During the detail design process, it has become necessary to review aspects of the approved Planning scheme to resolve the requirements of the environmental design, in order to create optimal learning environment, as well as taking on board the recommendations of the Designing Out Crime Officer. The required changes are described below.

### Daylighting

| DRAWING TITLE | GA ELEVATION            |               |

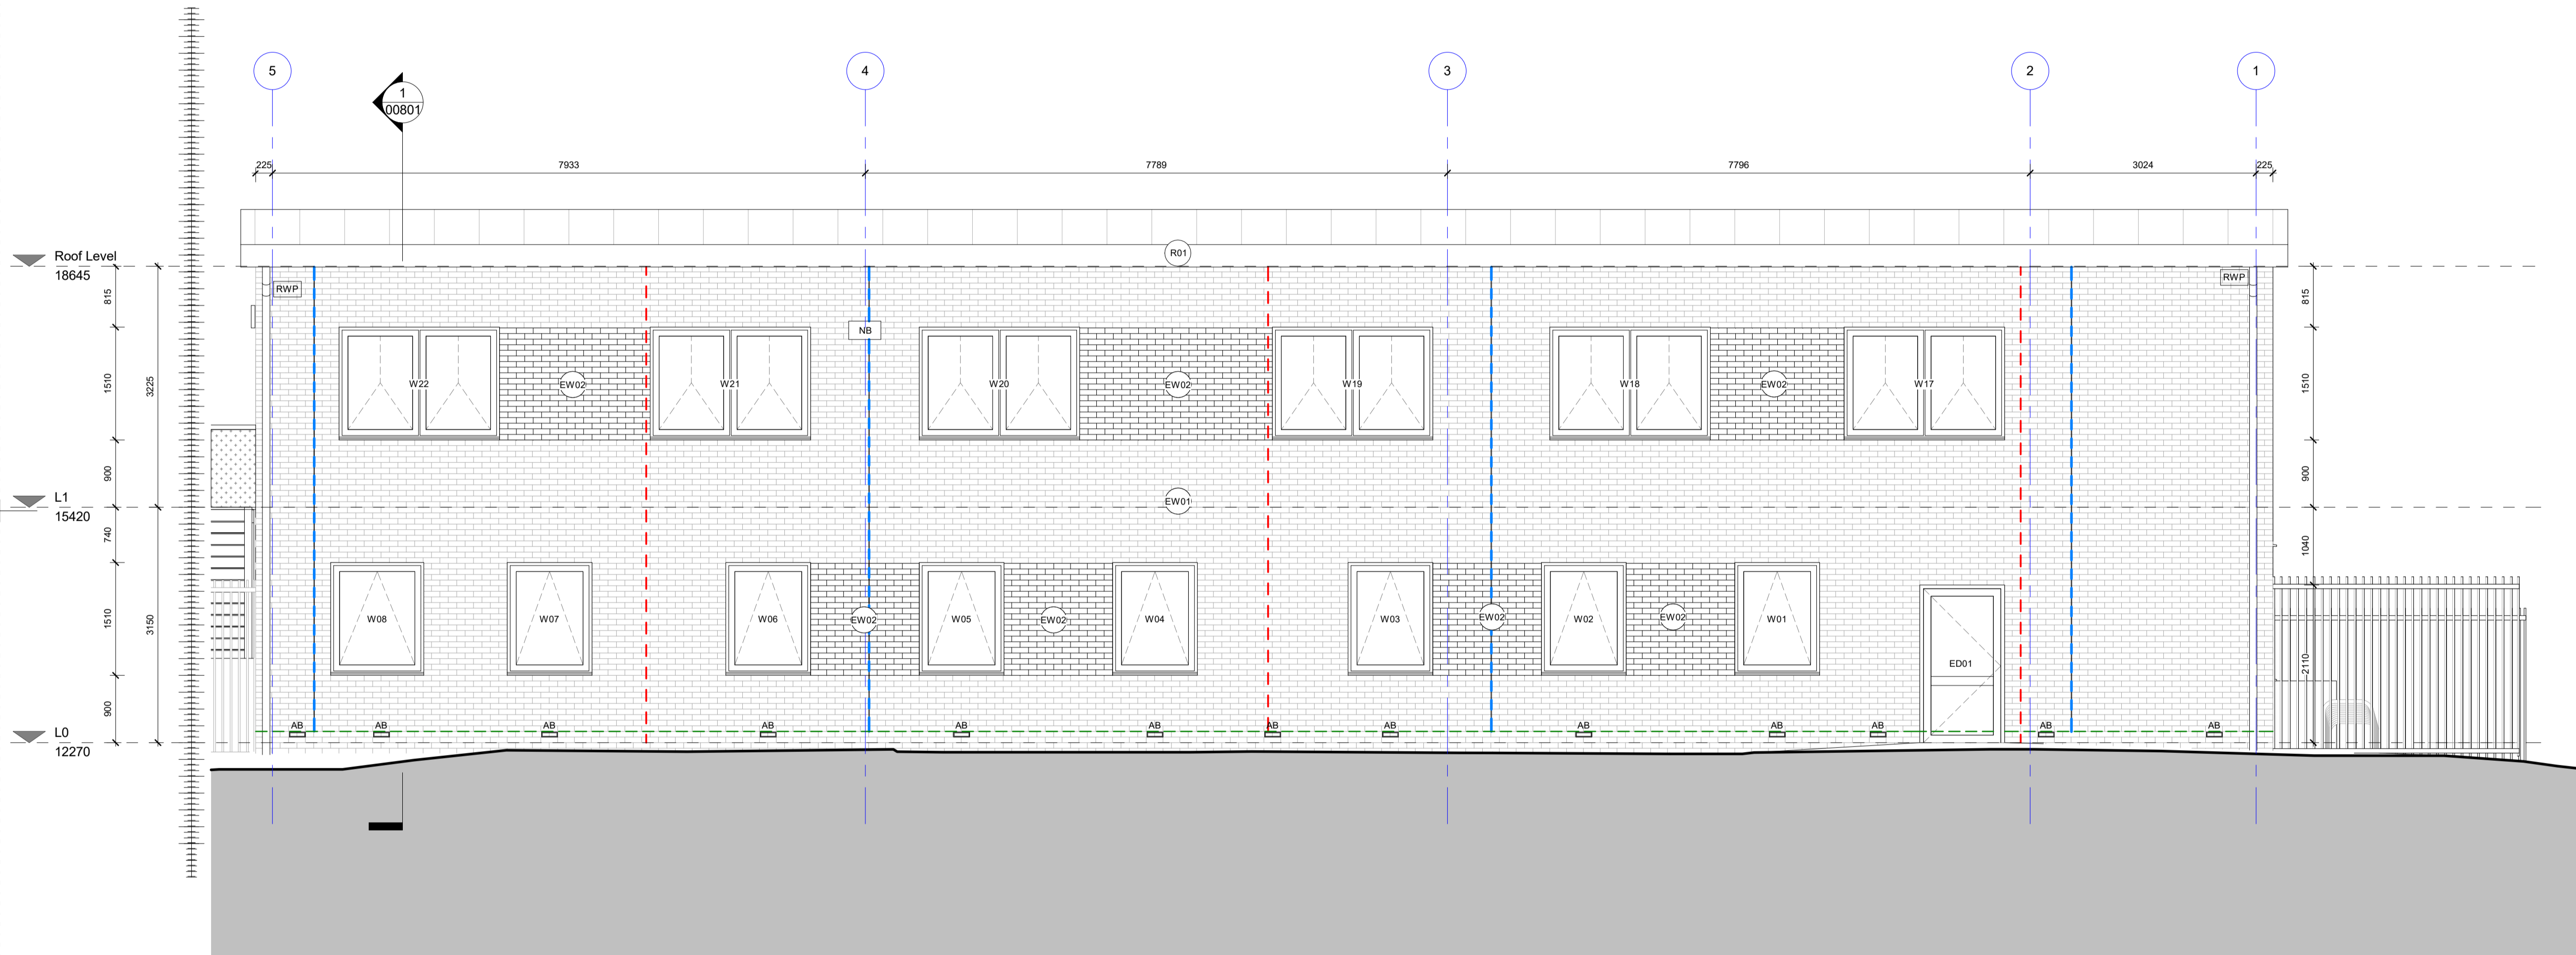
As a result of changes to the internal layout – following a strategic review by the Head Teacher – the placement of rooms at first floor is broken by the presence of a small office in the middle. The addition of a dedicated window improves the internal environment and also have a positive impact on the balance of the elevation. One external door at Ground Floor has also been replaced by a window.

To achieve the same design principles as the original scheme, we have connected each pair of windows by special brickwork - whereas previously there were 3 large windows, all connected together. We feel this achieves the same design aesthetic, but with the significant benefit of improving the teaching environment for the school's students.

*Planning Approved Scheme – Street Elevation*

*Proposed Alternative – Street Elevation*

Drawing title: Replacement Tree Planting Strategy Plan

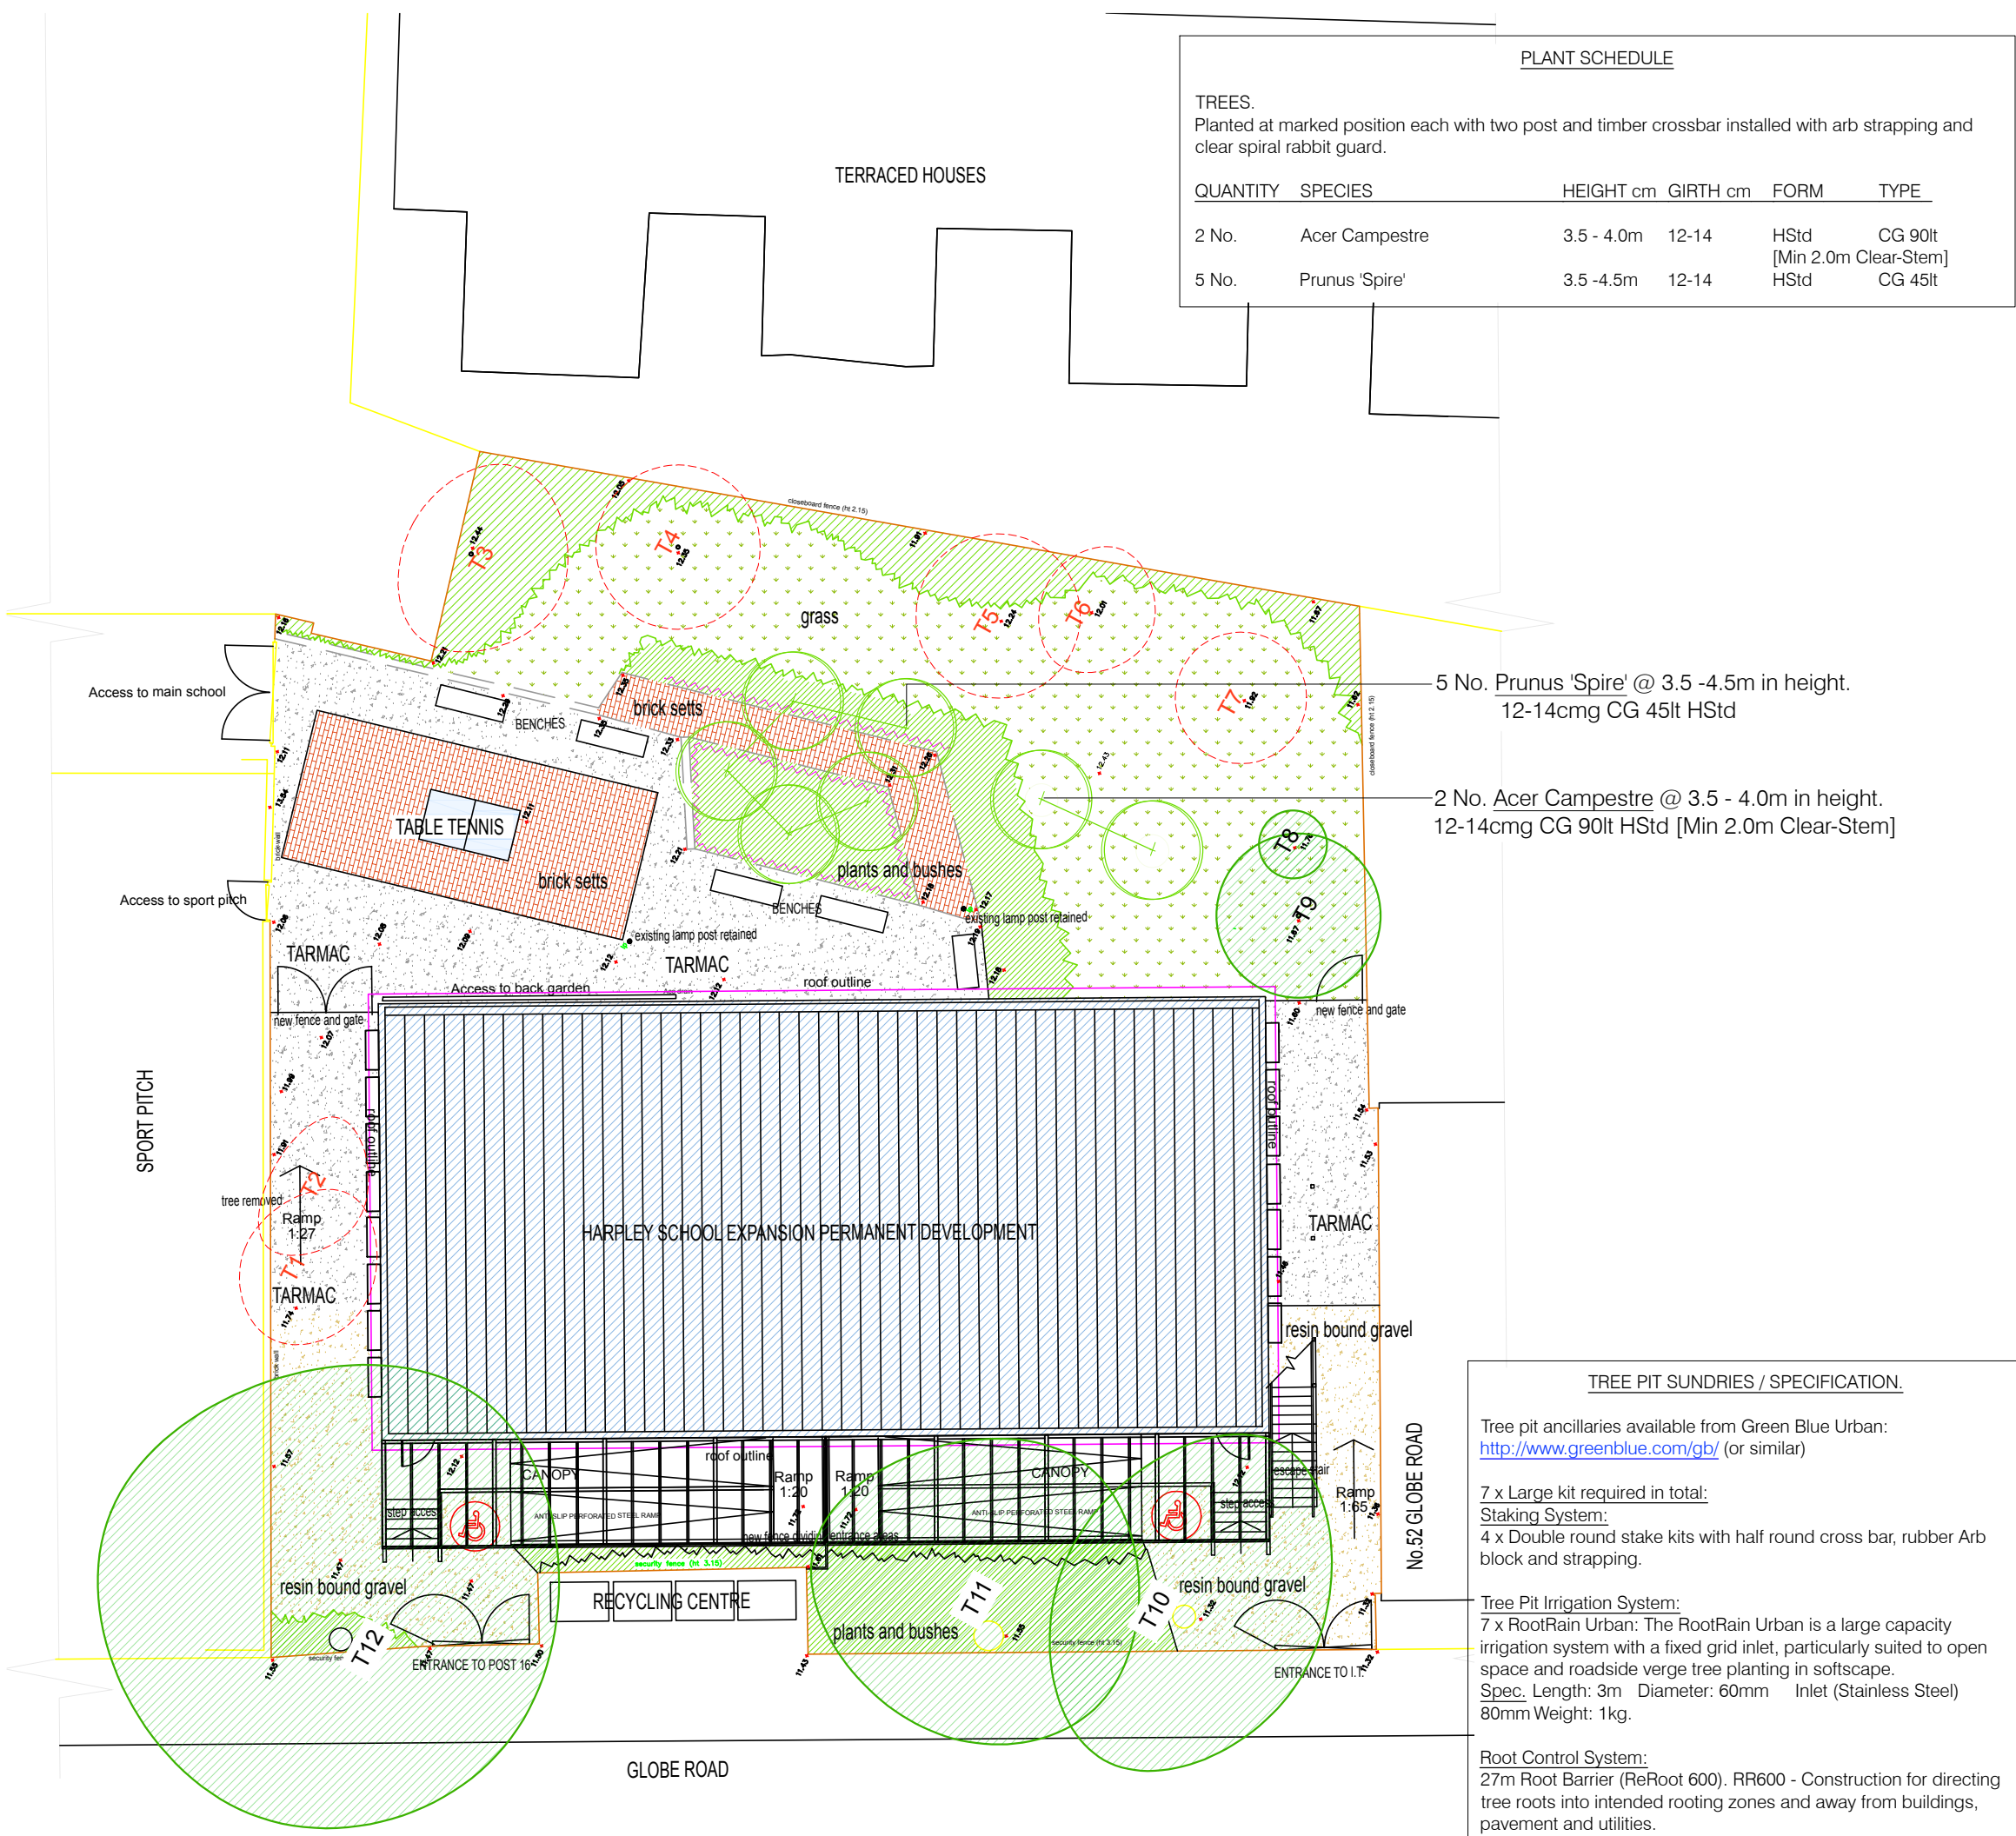
The original scheme transplanted a number of trees into new position, however the condition of these trees was deemed to be poor and would not survive the transplantation. As such, these are being replaced instead. Furthermore, a significant complaint was received from a neighbouring resident regarding a number of existing trees. It has therefore been agreed to remove these and replace them away from the boundary so as not to cause a nuisance. Extensive consultation has been undertaken with the Tree officer & Biodiversity officer regarding the proposed removal & replacement. Further details are provided in the accompanying arboricultural report.
